Application: SSI 7485

I write regarding the proposed modification to M4-M5 Link, Mod 2 The Crescent overpass and changes to pedestrian infrastructure in North Annandale, Rozelle and Rozelle Bay Foreshore area.

Figure 4-2 Pedestrian and cyclist bridge infrastructure options

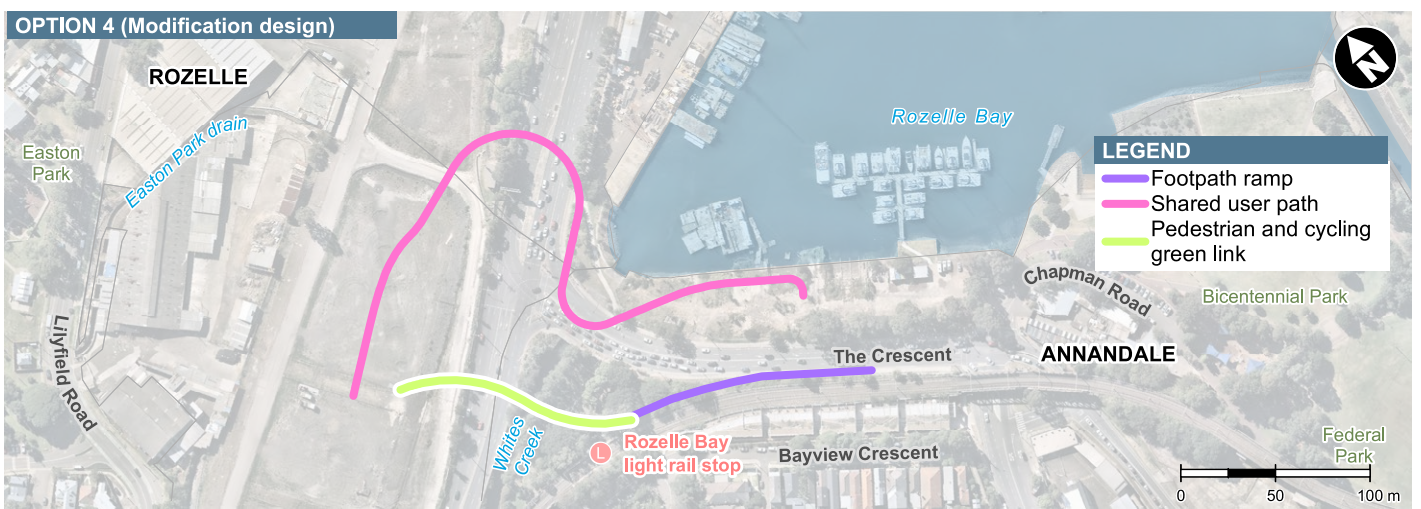
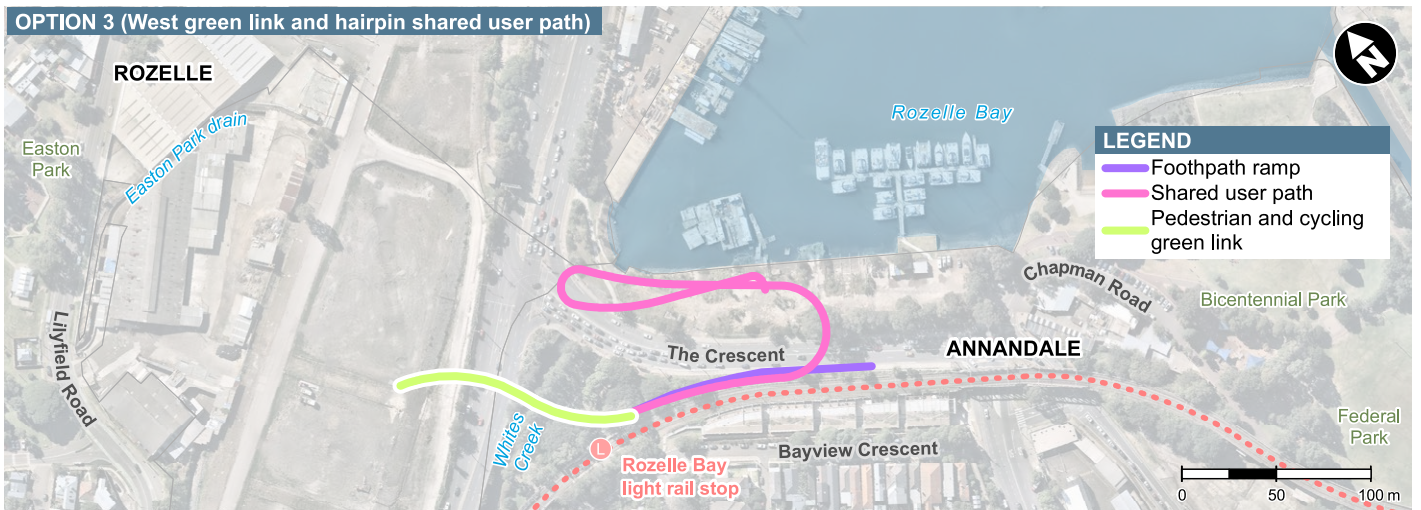
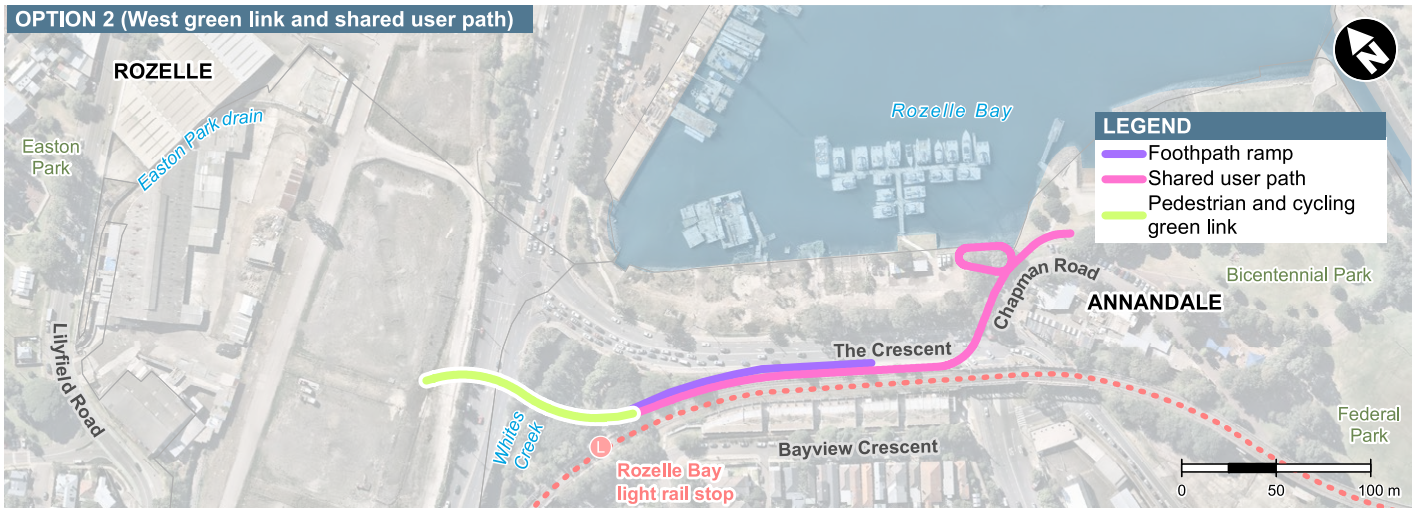
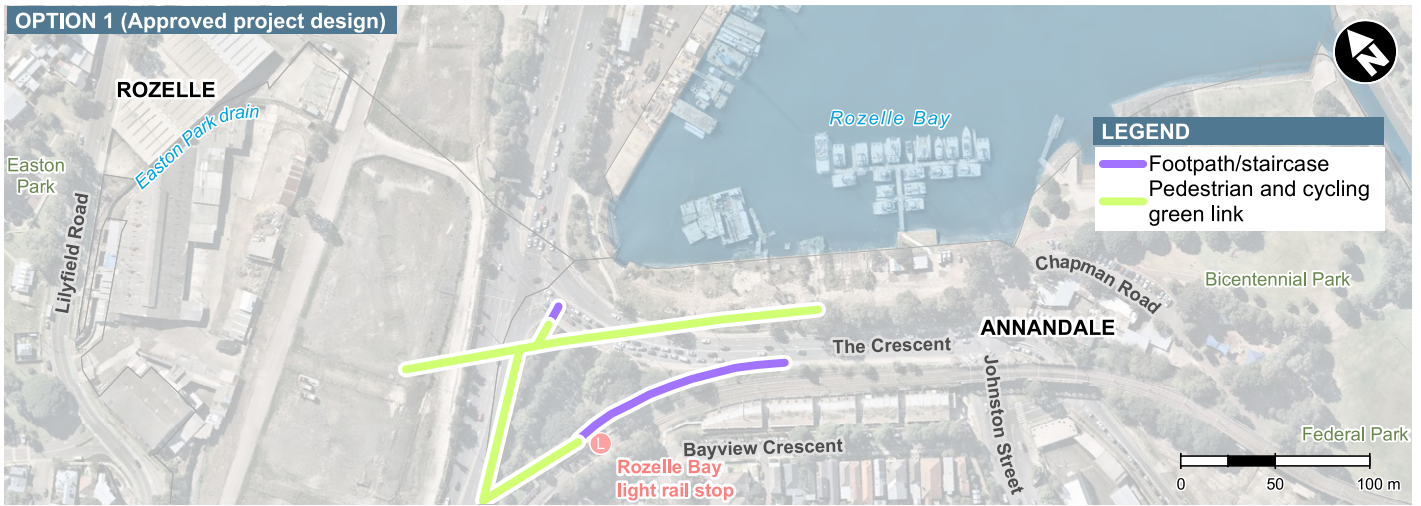
I request RMS work with the community to explore alternate design options to the proposed new car overpass design and the changed pedestrian and cyclist links. I am seeking the reinstatement of the safe, direct access from the approved EIS GreenLink to create a continuous green open space connection from the Rozelle Rail yards and Annandale to the foreshore. The GreenLink was more than just a walk way - it put people central to the design, maximising safety, and providing much needed accessible open space for the community now and into the future Bays Precinct design.

- The significantly reduced safety and increased risk for pedestrians and cyclists with removed access over The Crescent to Bicentennial Park and the increased traffic along Johnson Street.
- Being required to cross five sets of pedestrian lights at The Crescent as my option to reach the foreshore from Annandale or from Rozelle Bay light rail stop.
- Removal of direct active links to the foreshore, cutting the community off from the area and the proposed revitalisation of the entire Bays Precinct, including linking the Light Rail and Bus stops to a Ferry wharf and Metro station.
- Urban and landscape design that is being built before a finalised Masterplan for the area.
- Traffic changes that limit movements around the suburb and create further congestion in the local streets of Annandale, Forest Lodge, Glebe, Lilyfield and Rozelle with no planning to deal with these.

- Reinststate the GreenLink connecting communities and green open space from Rozelle to Bicentennial Park
- Relocate and design pedestrian and cyclist connections that are continuous, safe and direct.
- Design the modification infrastructure and active links in response to the character of the suburbs, the location of the foreshore and it's potential future development.
- Provide pedestrian and cyclist paths that maximise people safety and do not force them onto busier streets, unsafe concrete plazas and caged walkways.
- Integrate active and direct connections to all active transport – including the future Metro West and Foreshore Ferry Wharf
